From: Mark Anderson [REDACTED]
Sent: 04 August 2021 20:04
To: Planning <Planning@arun.gov.uk>
Subject: STRONG OBJECTION TO Planning application WA/63/21/PL: Land East of Tye Lane, Walberton

Re: *OBJECTION : Planning application WA/63/21/PL: Land East of Tye Lane, Walberton.*

VIEWPORT 1 - PROPOSED RESIDENTIAL ACCESS AT TYE LANE

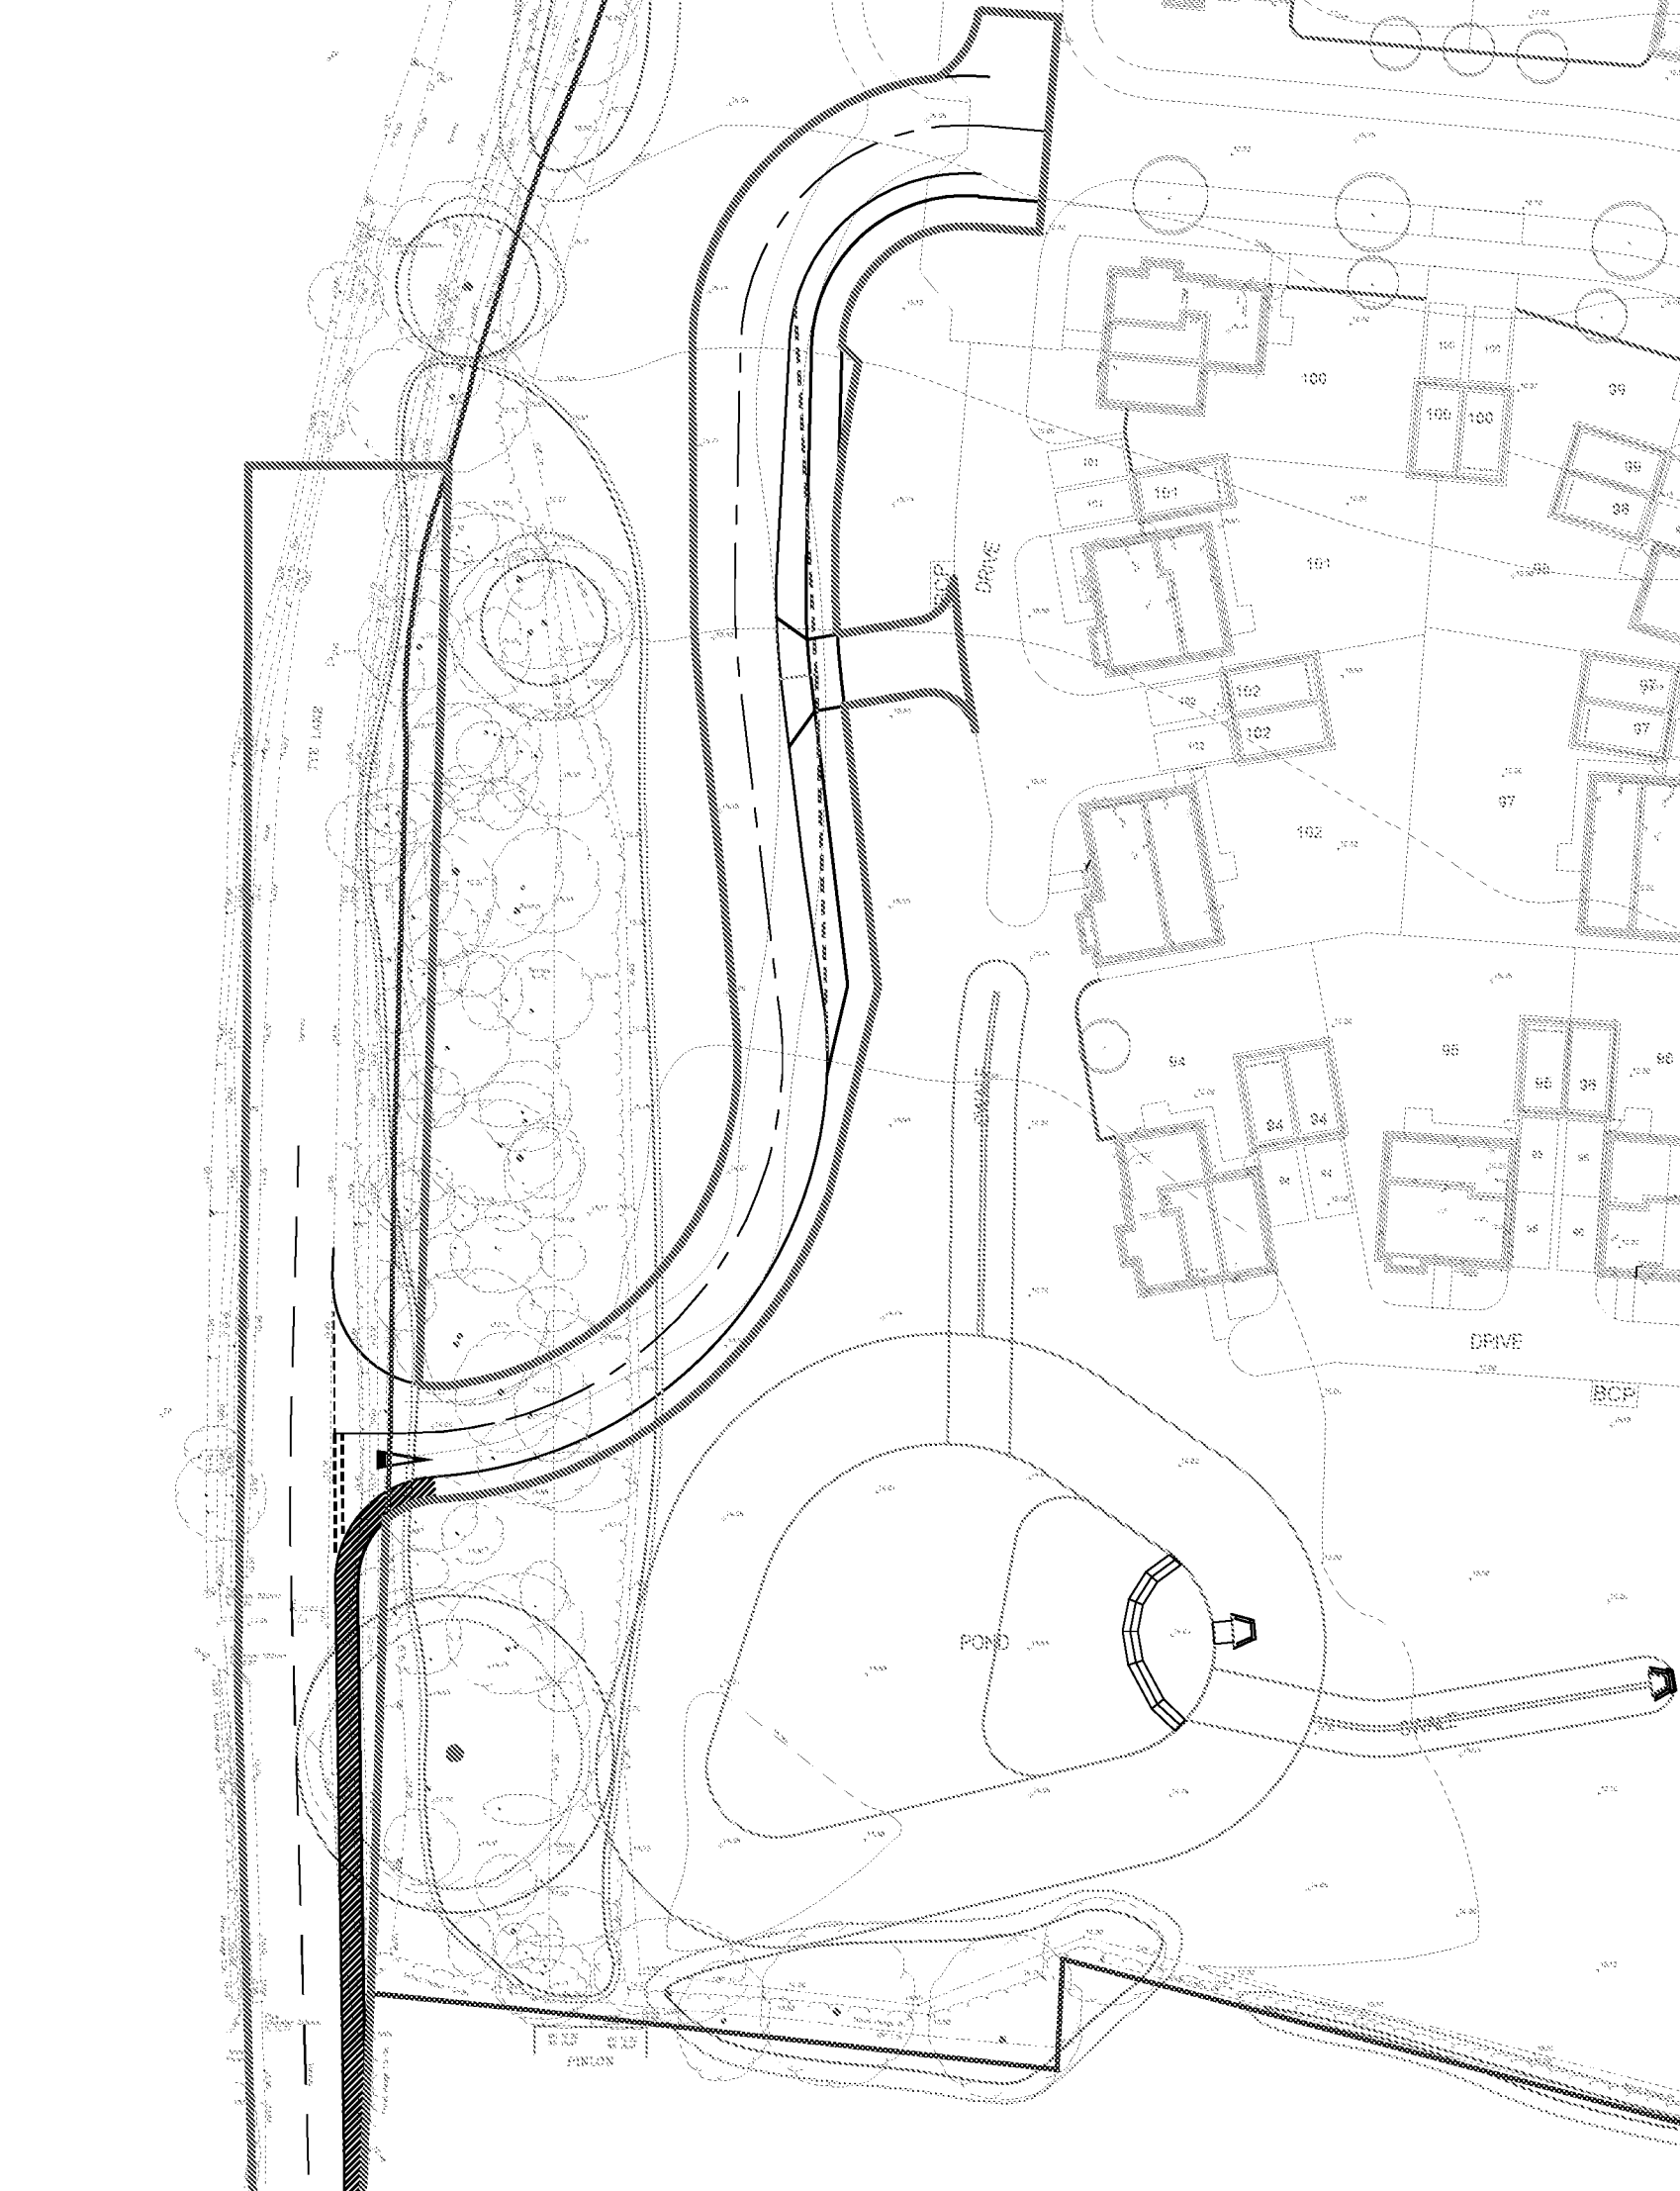
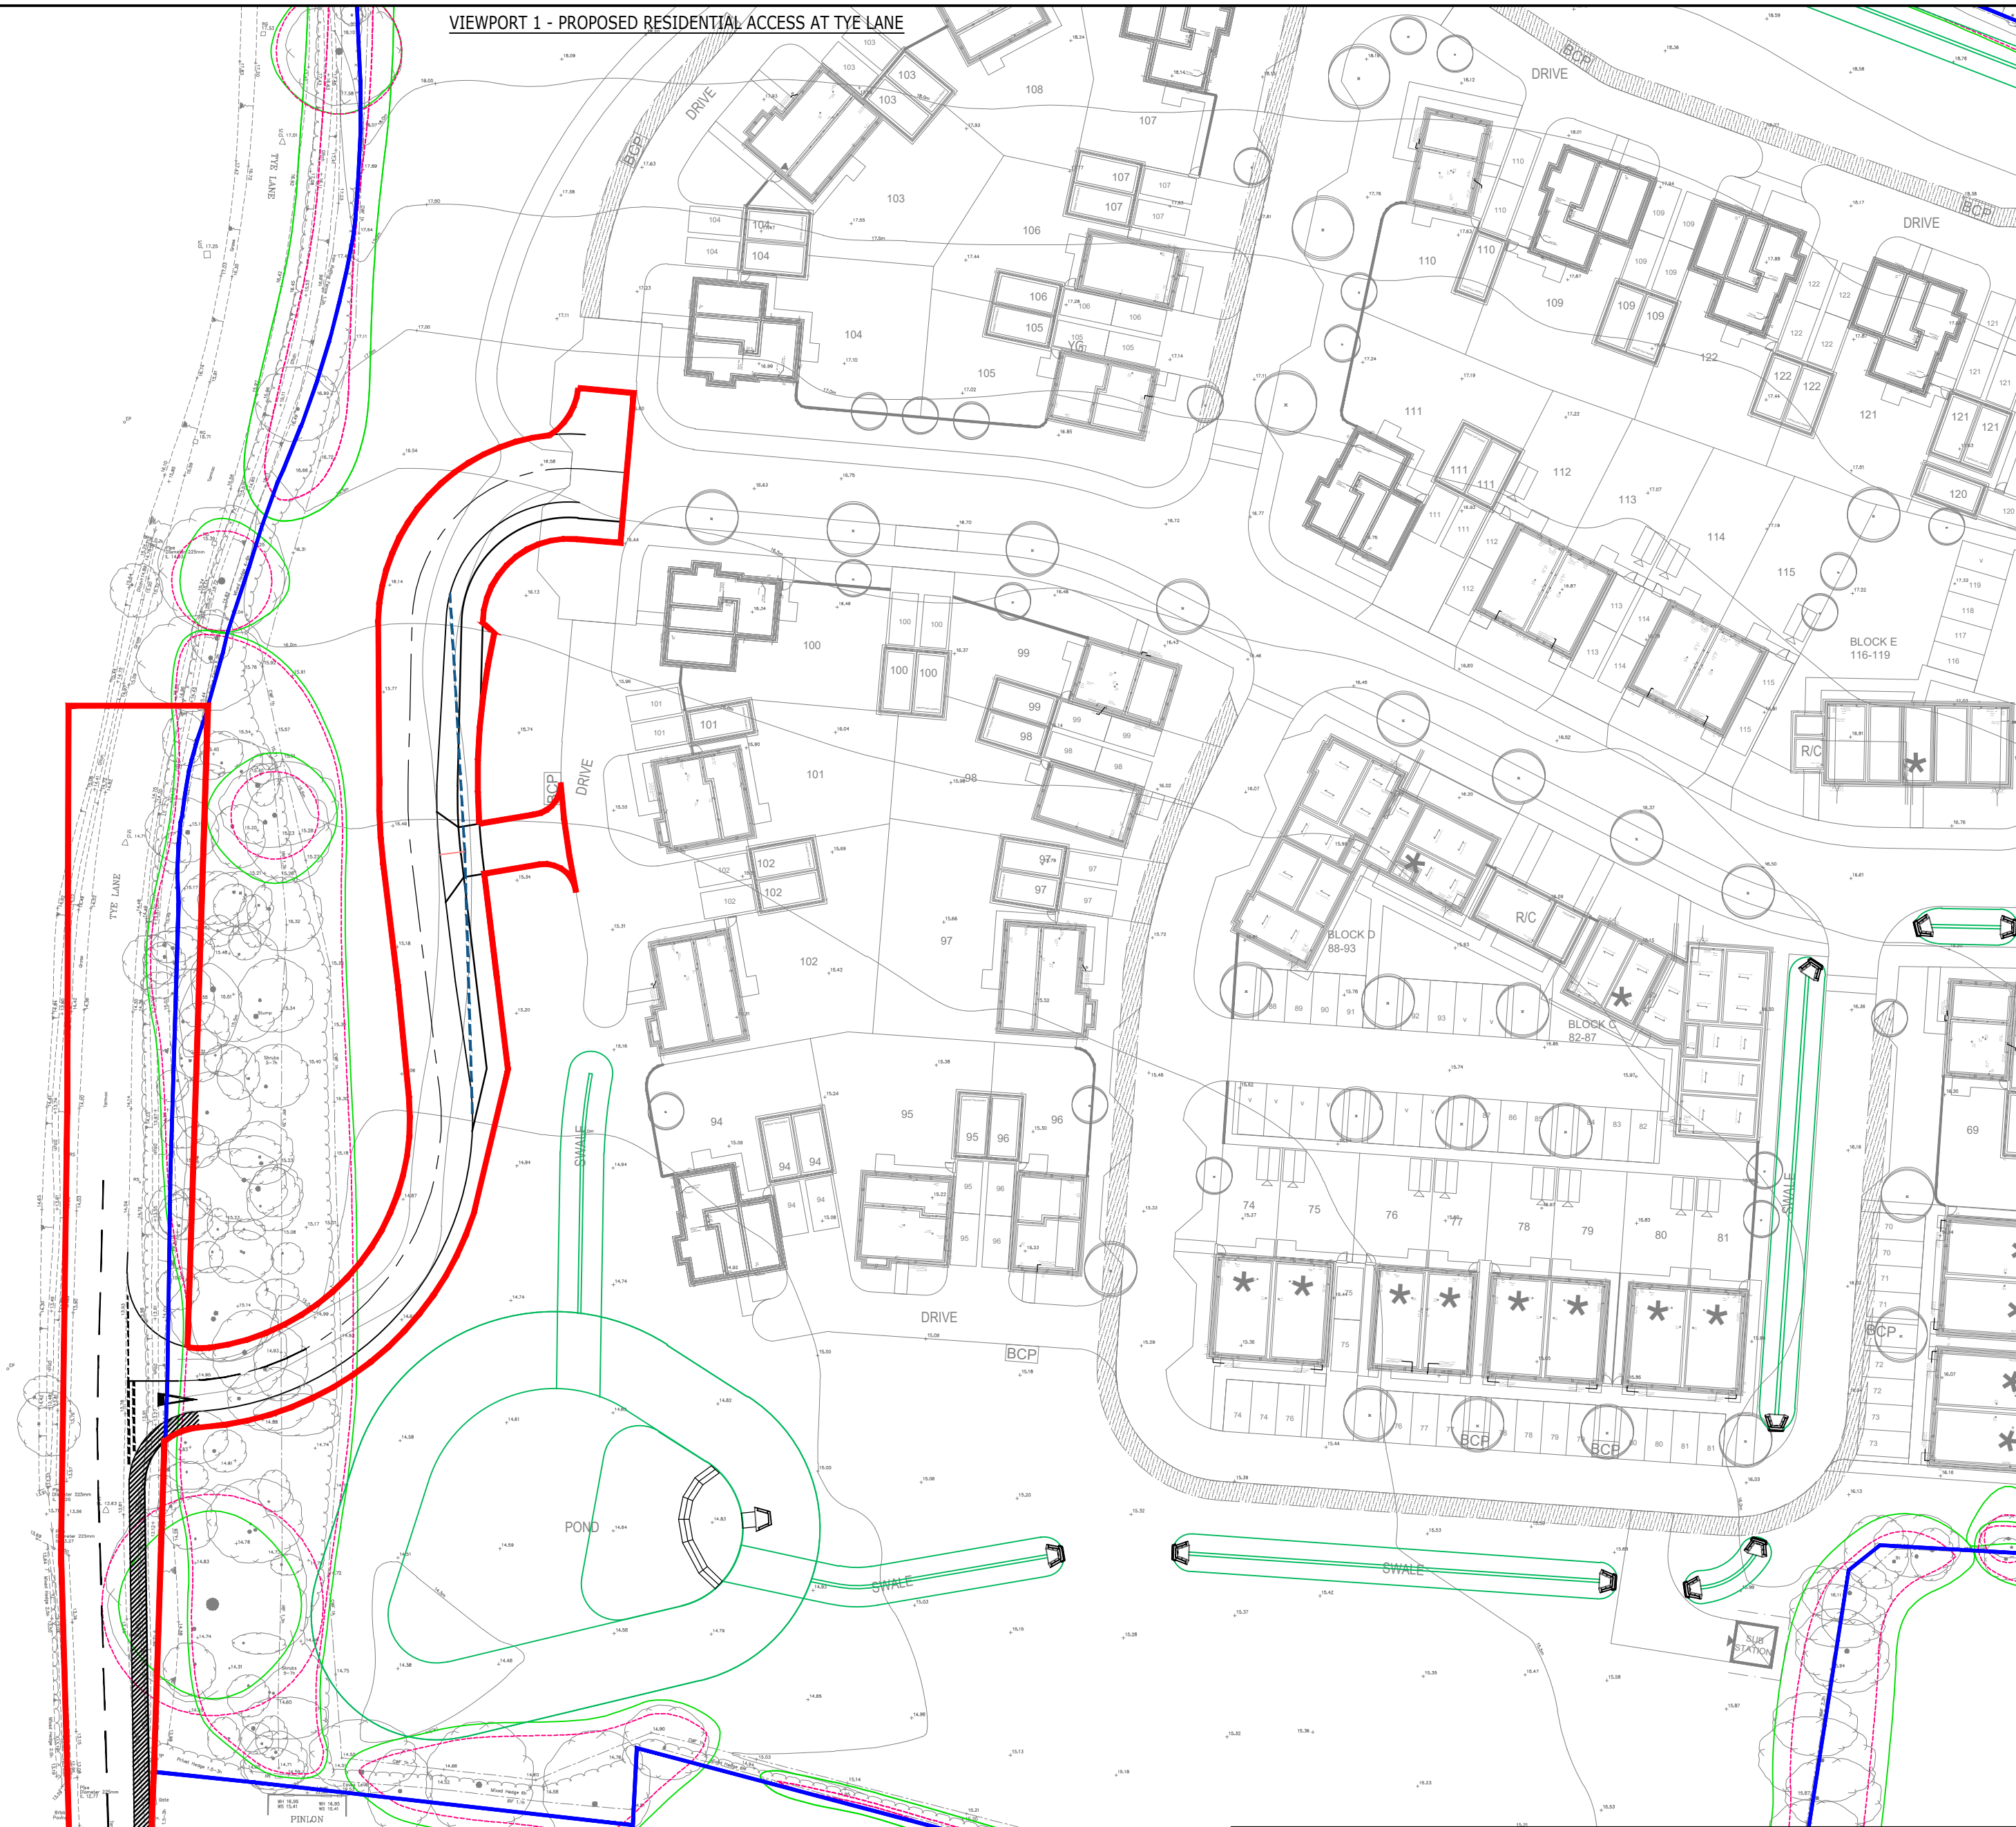
B. Road width change -Tye Lane is significantly narrower than Yapton Lane for vehicle movements. The new application reduces Tye Lane to a minimum of 4.8m rather than 5.0m for approximately 25m. This would mean that an HGV and a car could no longer pass at this point

(there is zero clearance for such vehicles). The values used for car widths by the applicant do not include allowance for wing mirrors so vehicles would have to mount pavements to get past each other, however a number of houses own land right up to the highway boundary and also they have no parking so vehicles are parked on the road, further narrowing the lane. The proposed cycle route from Avisford Grange leads down this narrowed route. This will also pose increased risks to cyclists from traffic trying to pass them. I use this road for cycling and it is a death trap.
